Please ask for: Ms Iqraa Malik
Email: iqraa.malik@terraquest.co.uk
Telephone: 01212341390
Our Ref: LU/46/21/HH
Your Ref:
Date: 19th February 2021

Application for Planning Permission for Works or Extension to a Dwelling

Development: Single storey side/rear extension with alterations to front elevation
Location: 38 Lyminster Road Wick Littlehampton BN17 7LB

Block Plan shows area bounded by: 502675.84, 103555.02 502765.84, 103645.02 (at a scale of 1:500), OSGridRef: TQ 272 360. The representation of a road, track or path is no evidence of a right of way. The representation of features as lines is no evidence of a property boundary.

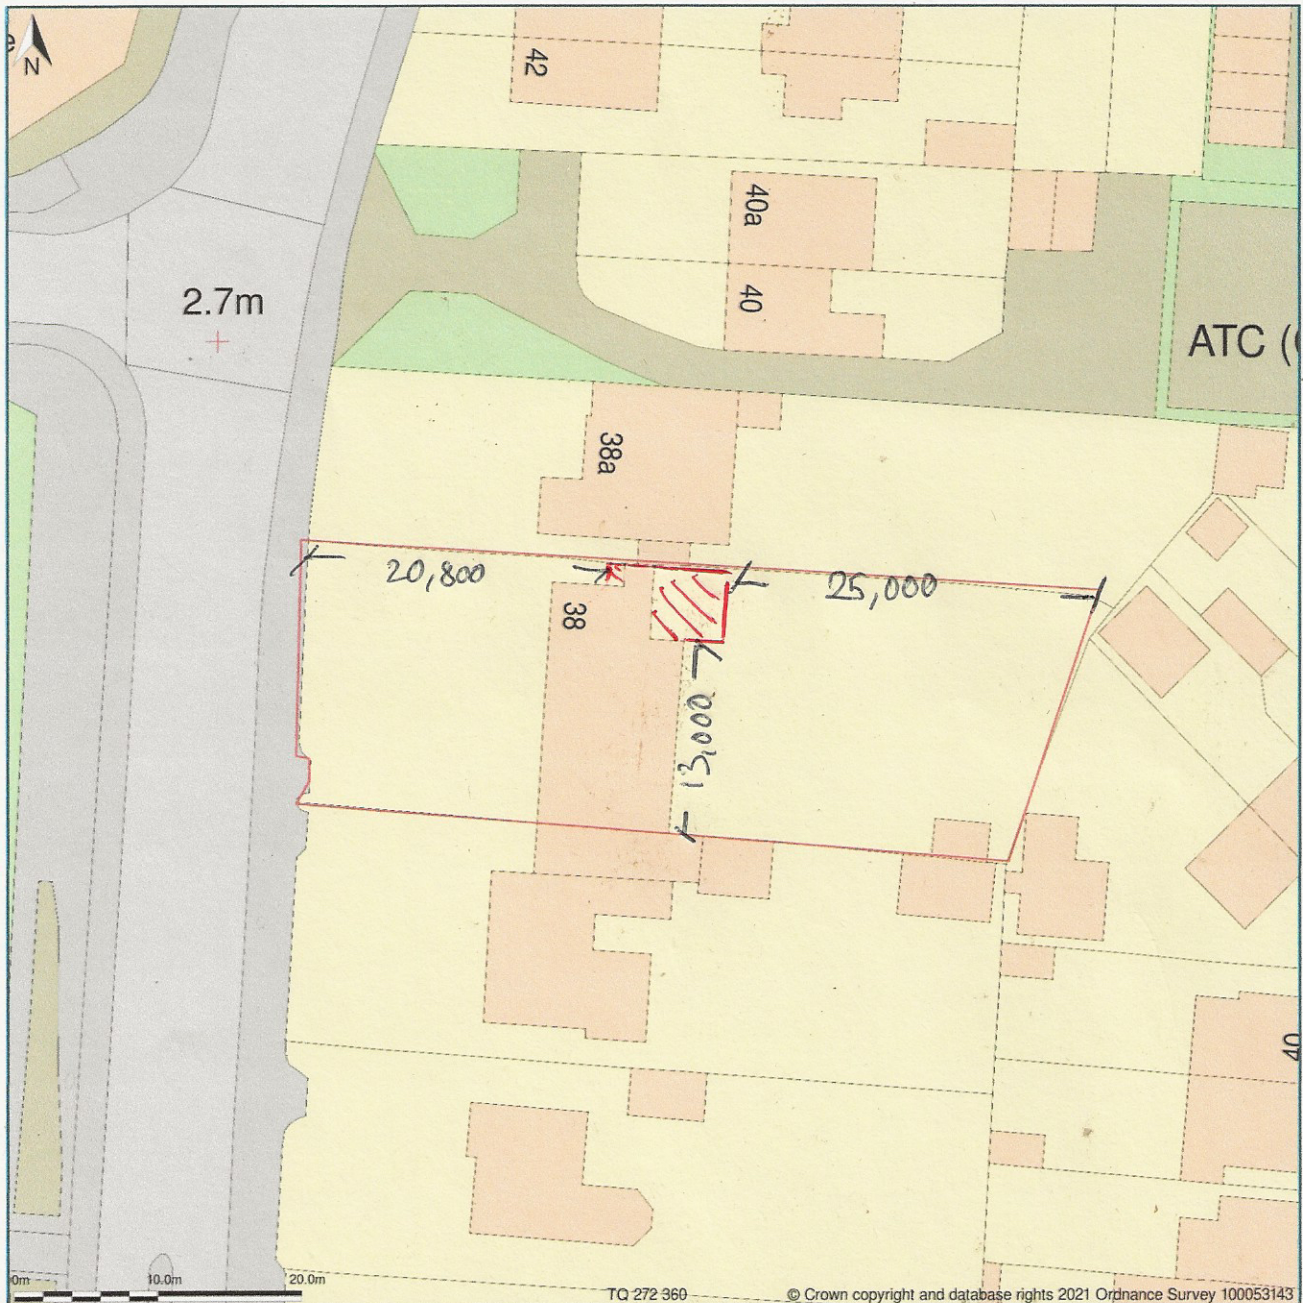
Block Plan: You are required to include dimensions on the block plan from the proposed extensions to all site boundaries.

Plan View Design

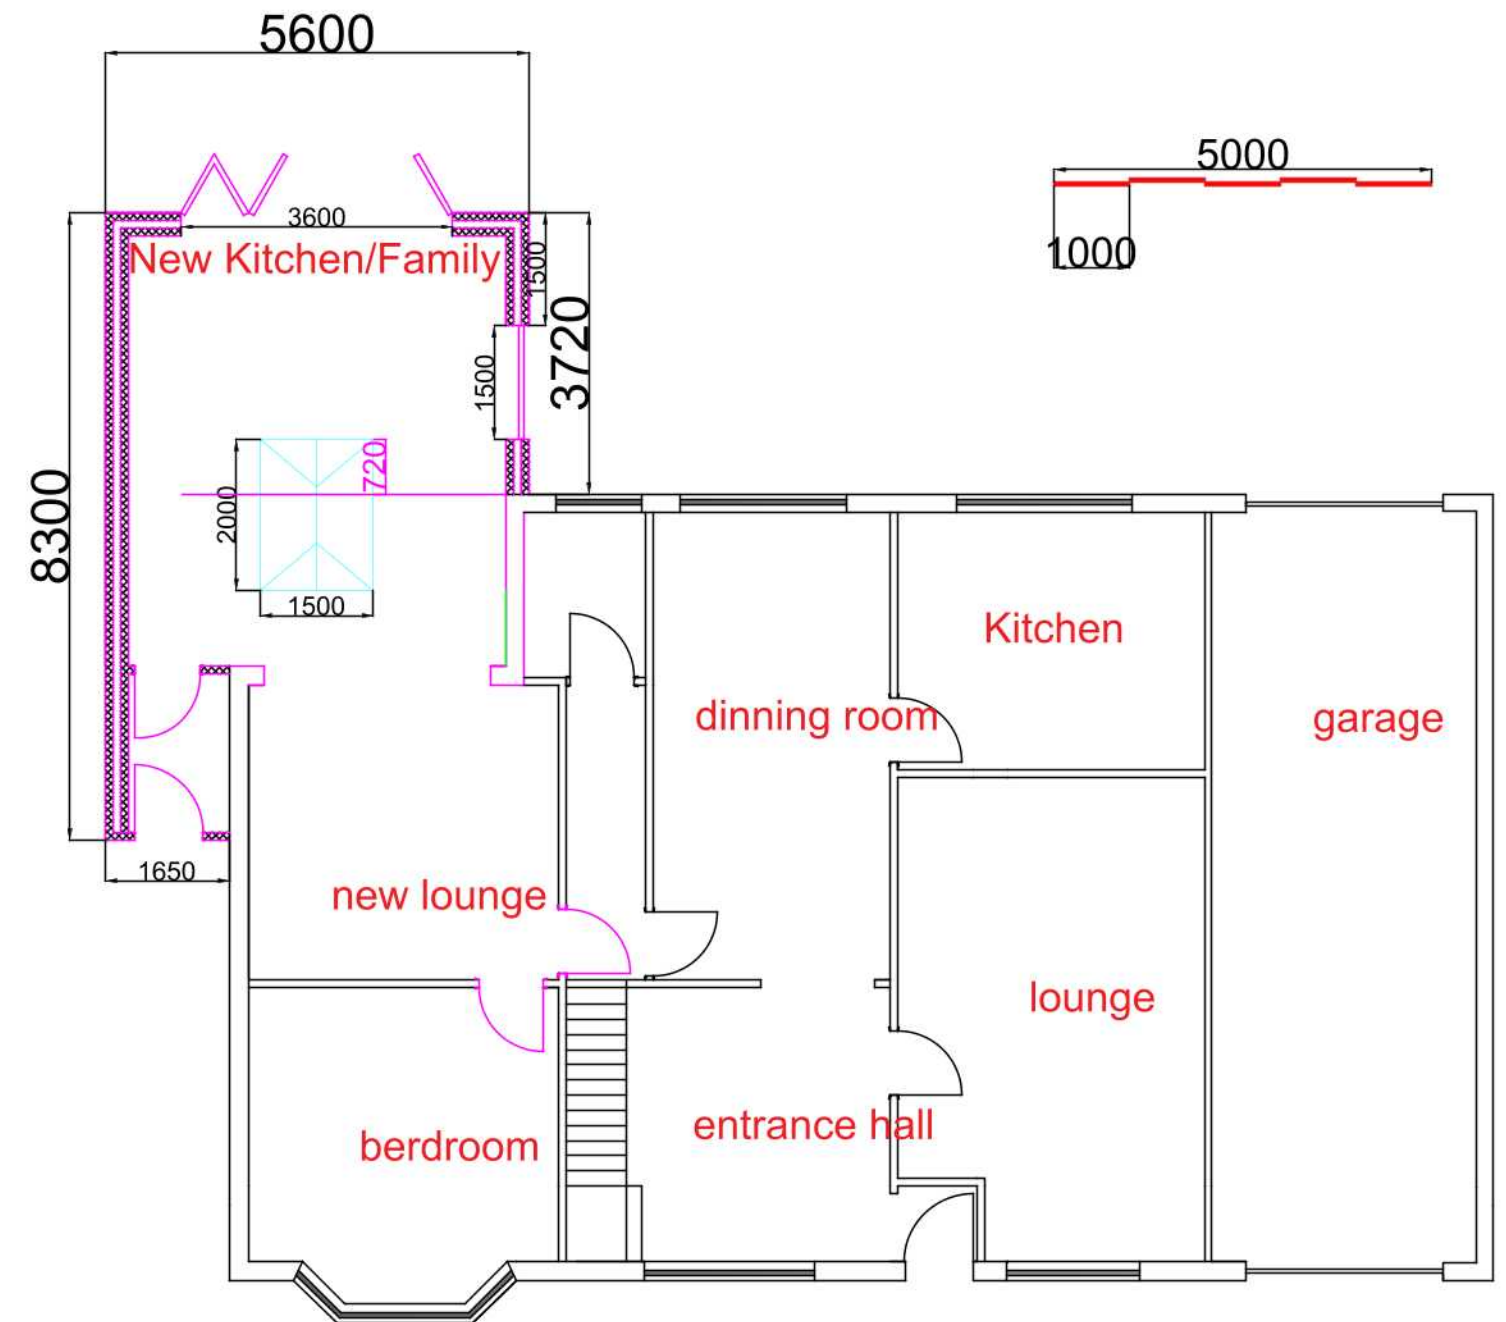
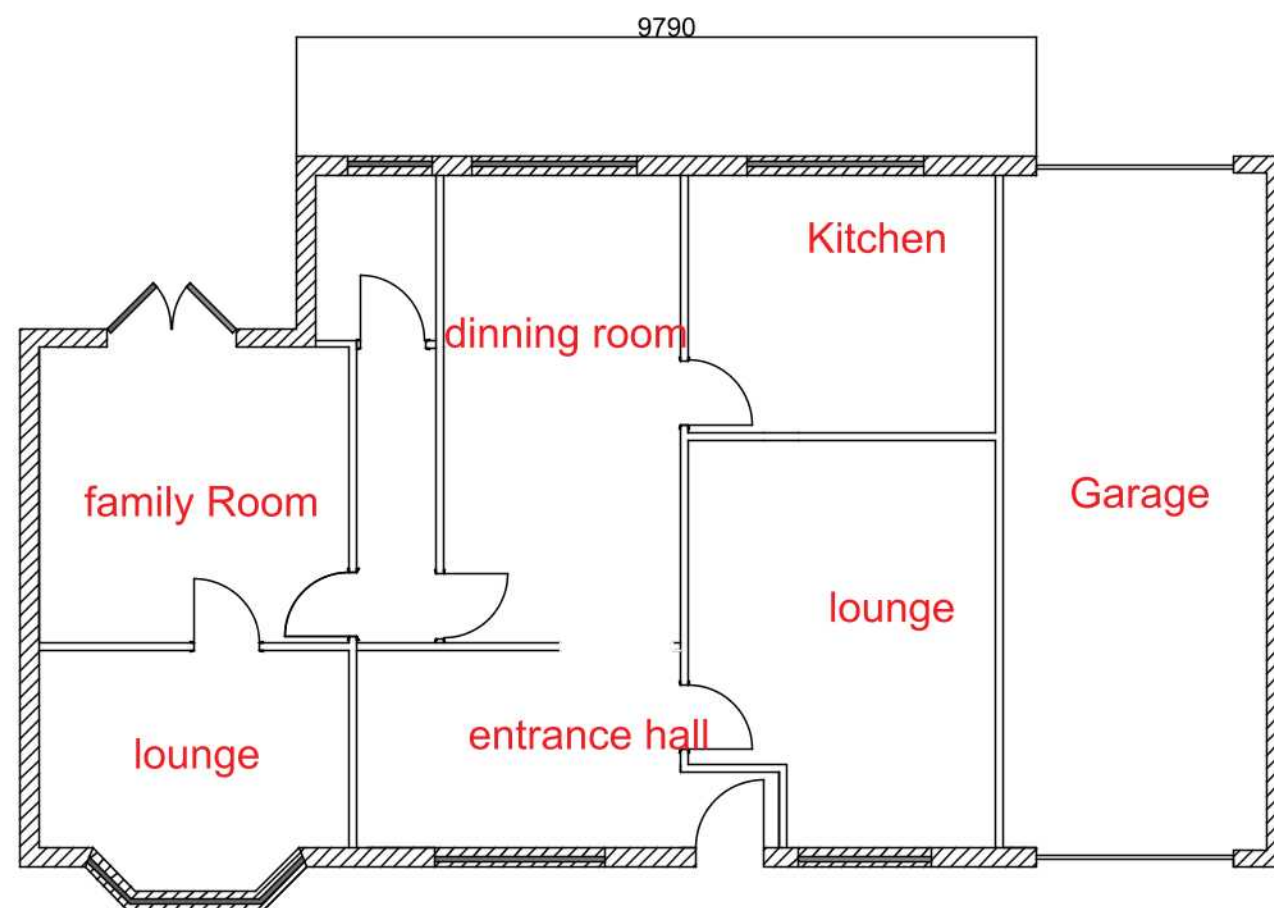
Room Labels: You are required to have room labels on all plans
